From: Sue Howell <Sue.Howell@arun.gov.uk>
Sent: 07 June 2022 12:30
To: Planning.Responses <Planning.Responses@arun.gov.uk>
Cc: Katie Sharp <Katie.Sharp@arun.gov.uk>
Subject: Planning Consultation on: FP/76/22/DOC

Application ref: FP/76/22/DOC

Description: Approval of details reserved by condition imposed under FP/248/20/PL relating to conditions 8-levels, 12-surface water drainage, 13-discharge flows to watercourses, 14-maintenance and management of surface water drainage system and 21-Landscape and Ecological Management Plan.

Location: Land North of Felpham Felpham

MUGA Layout, Build Up and Fencing

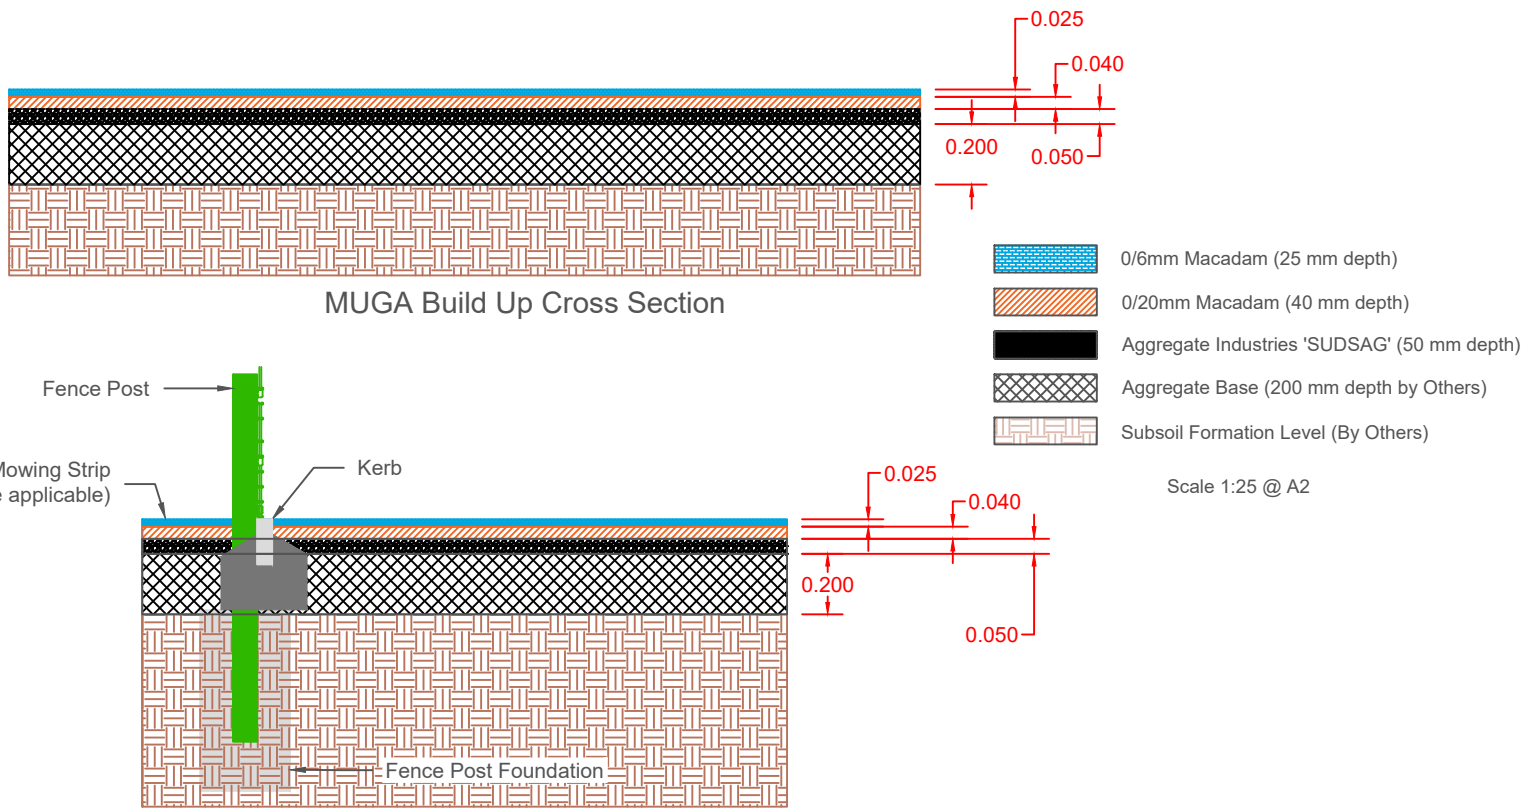
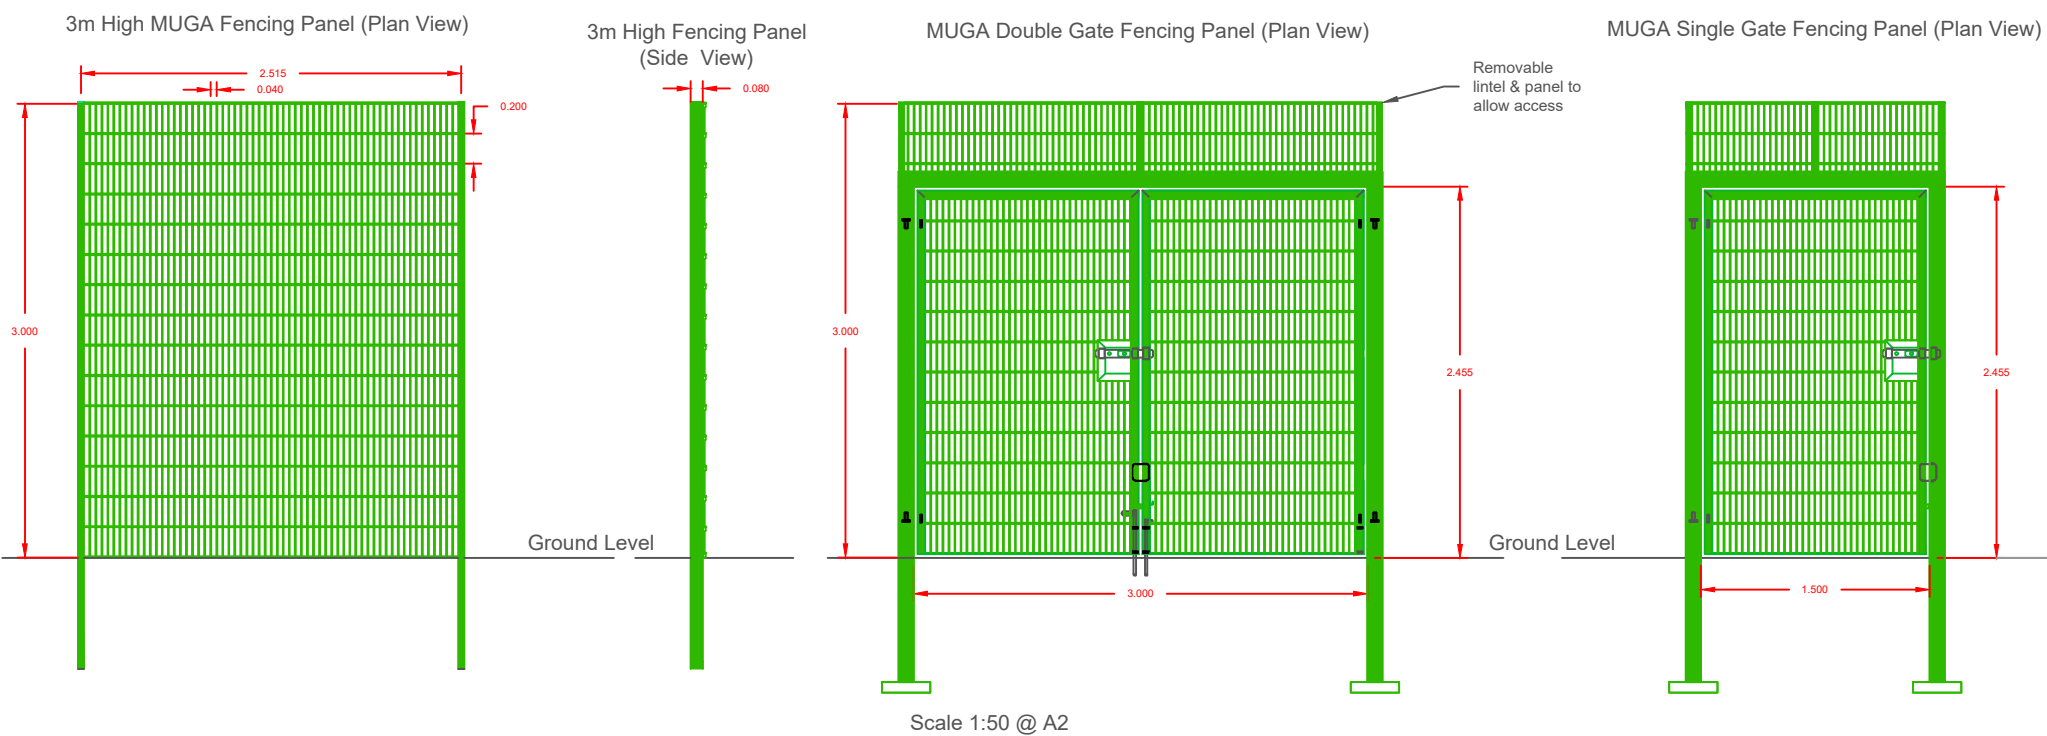
In addition to the above we note that it appears that the two MUGA's differ in that one has recessed football goals and the other assumed focussed on basketball. Worth noting that line markings or panels/fixings within the MUGA's will cater for as many sports as possible i.e. cricket, netball across the two facilities.
